Sent: 11 January 2013 13:09  
To: Planning  
Subject: Planning application S6/2012/2608/MA - Nyn Park, Well Road

**Response to Planning application from Hertfordshire County Council (T and CP GDP Order 1995)**

**District ref:** S6/2012/2608/MA

Replacement boundary fence to Nyn Park Estate

TITLE
Proposed Boundary Fence (60f6)

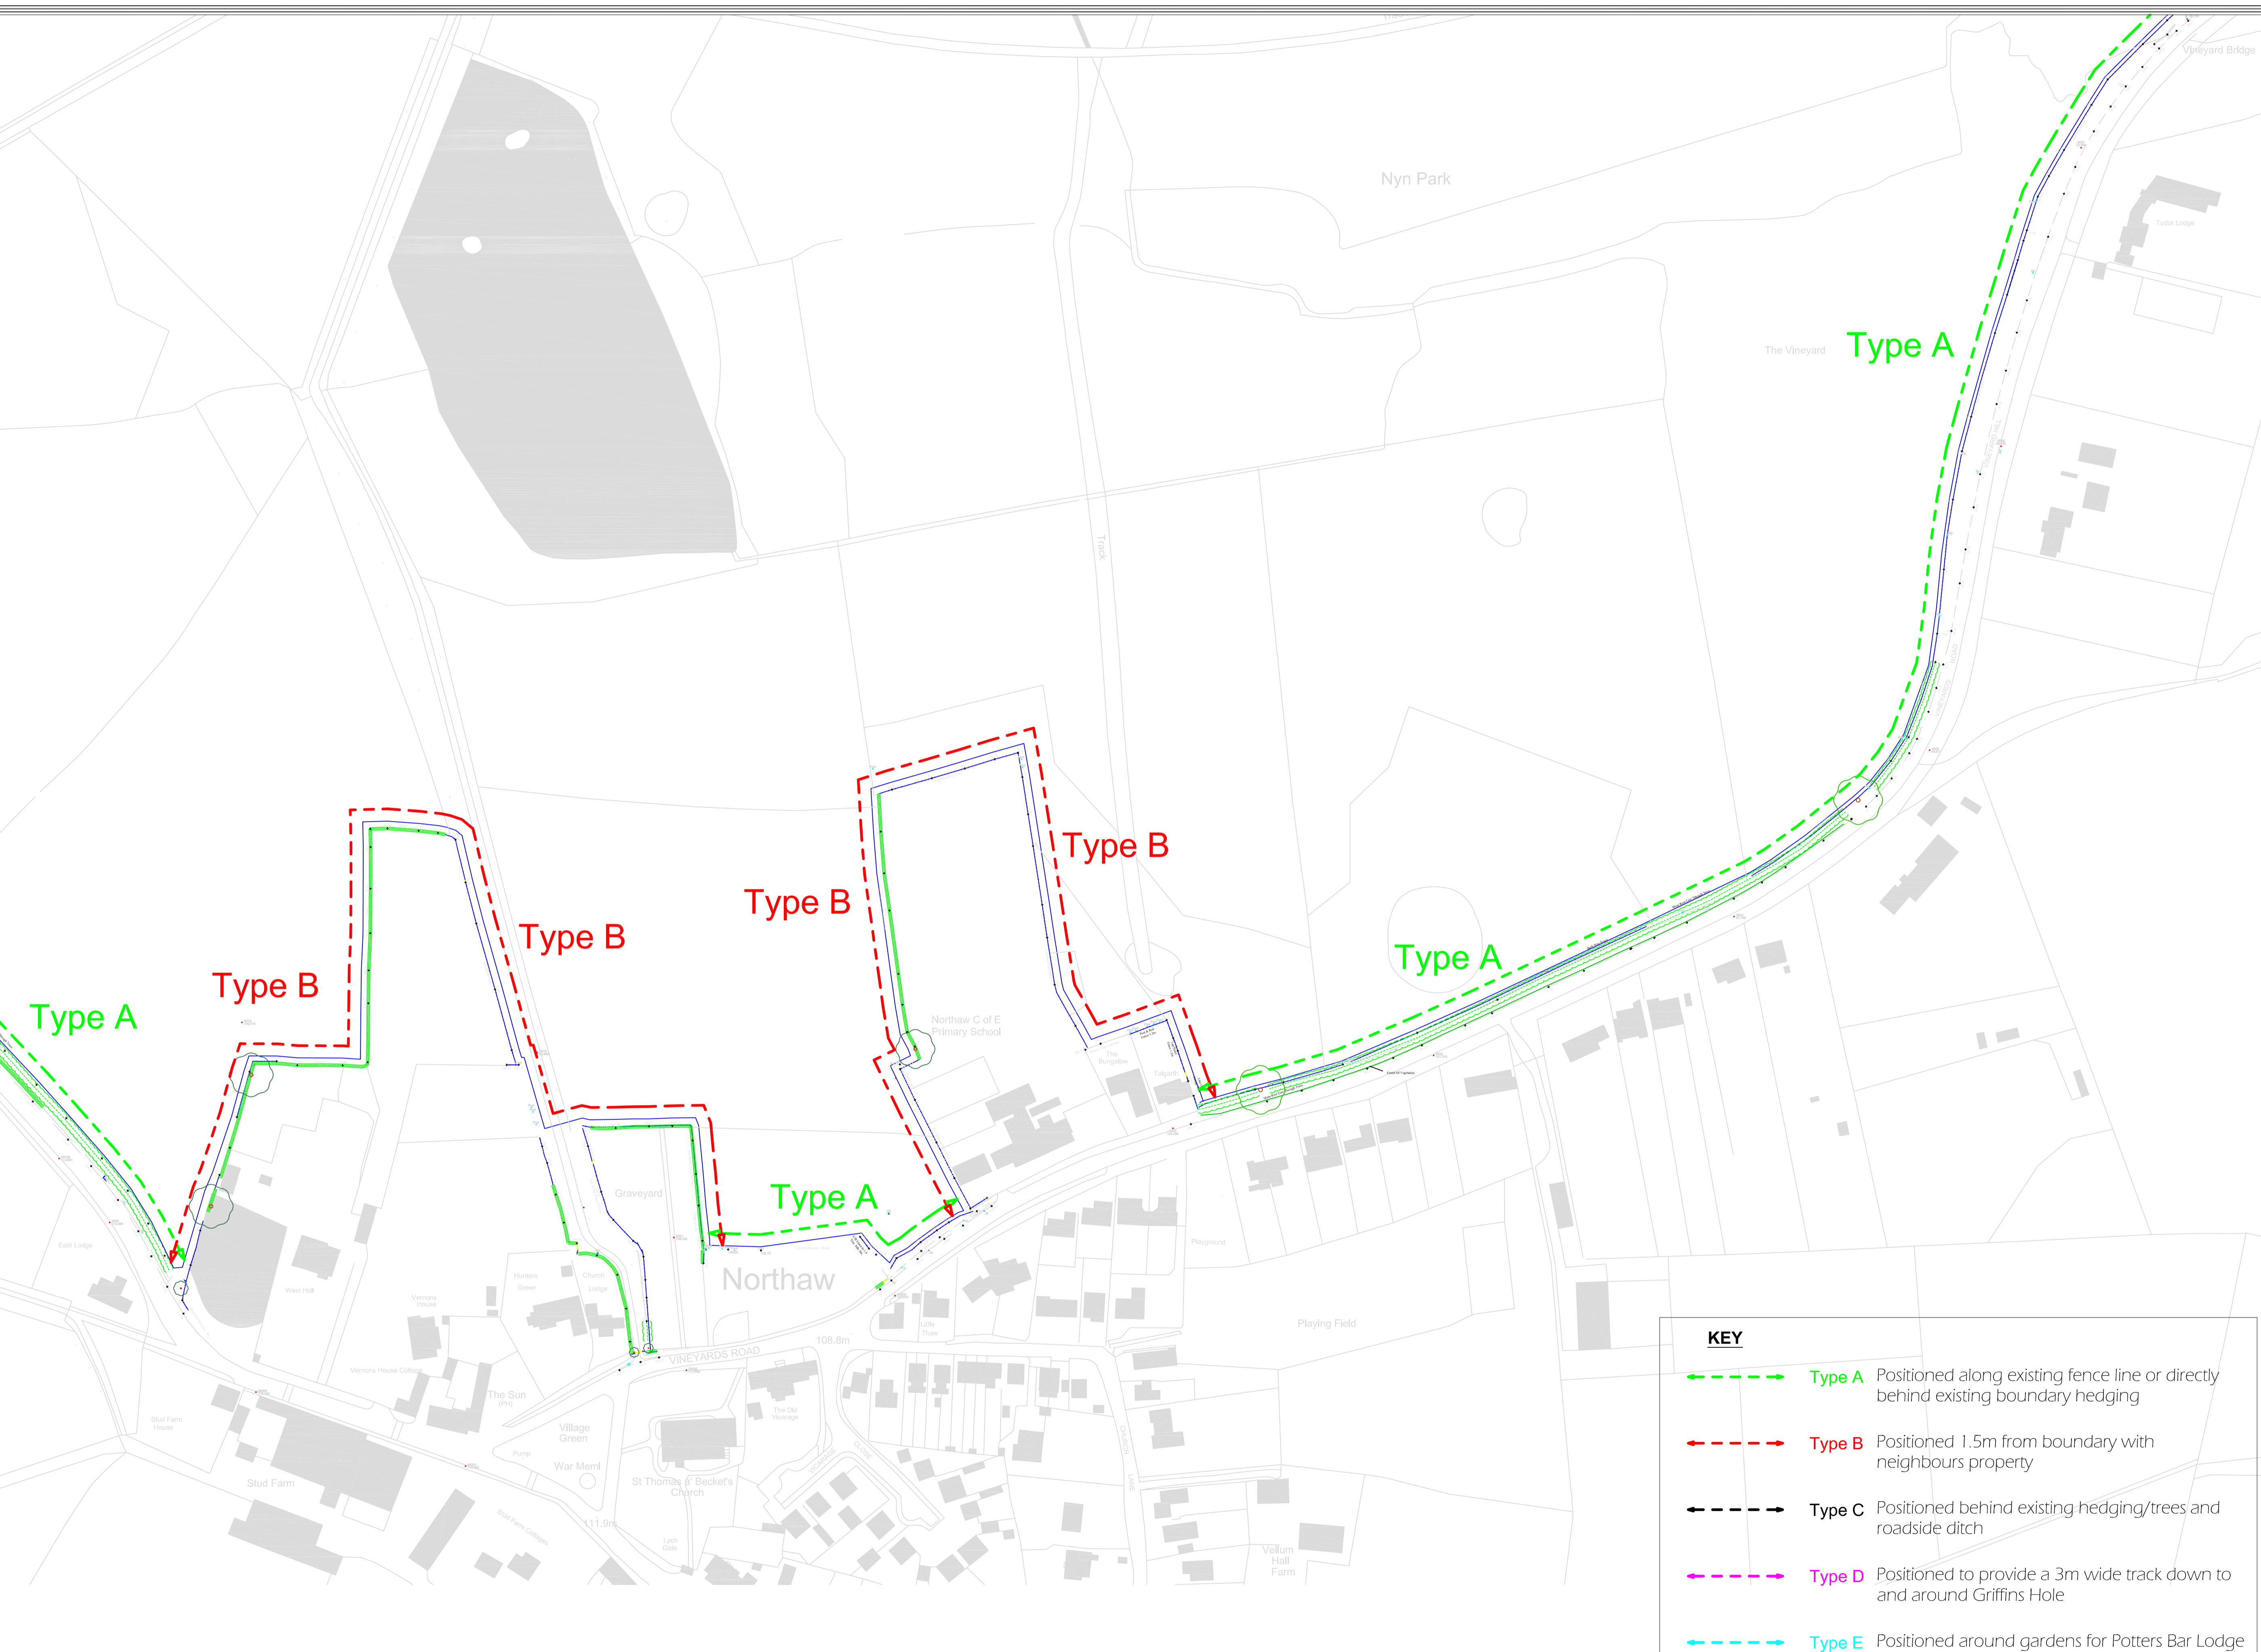
1. No development shall commence until a scheme for the proposed fencing adjacent to the Public Right of way Footpath Northaw 005 has been submitted to and approved in writing by the local planning authority and the County Councils Rights of Way unit. Thereafter the development shall be carried out in accordance with the approved details.

This application is for the installation of replacement boundary fence to Nyn Park Estate. The proposal will include new fencing adjacent to the public right of way, Footpath Northaw 005 which leads to Griffins Hole well. The plans are not detailed enough to show how the proposed fencing will impact on this Right of Way and therefore I recommend the inclusion of the above condition. The proposed fencing should not reduce the width of the existing Right of Way which is approximately 15m and fencing should be placed behind the historic banks which line this route. Details of all work to this part of the boundary should be agreed with the Rights of way unit of Hertfordshire County Council prior to the commencement of the fencing.
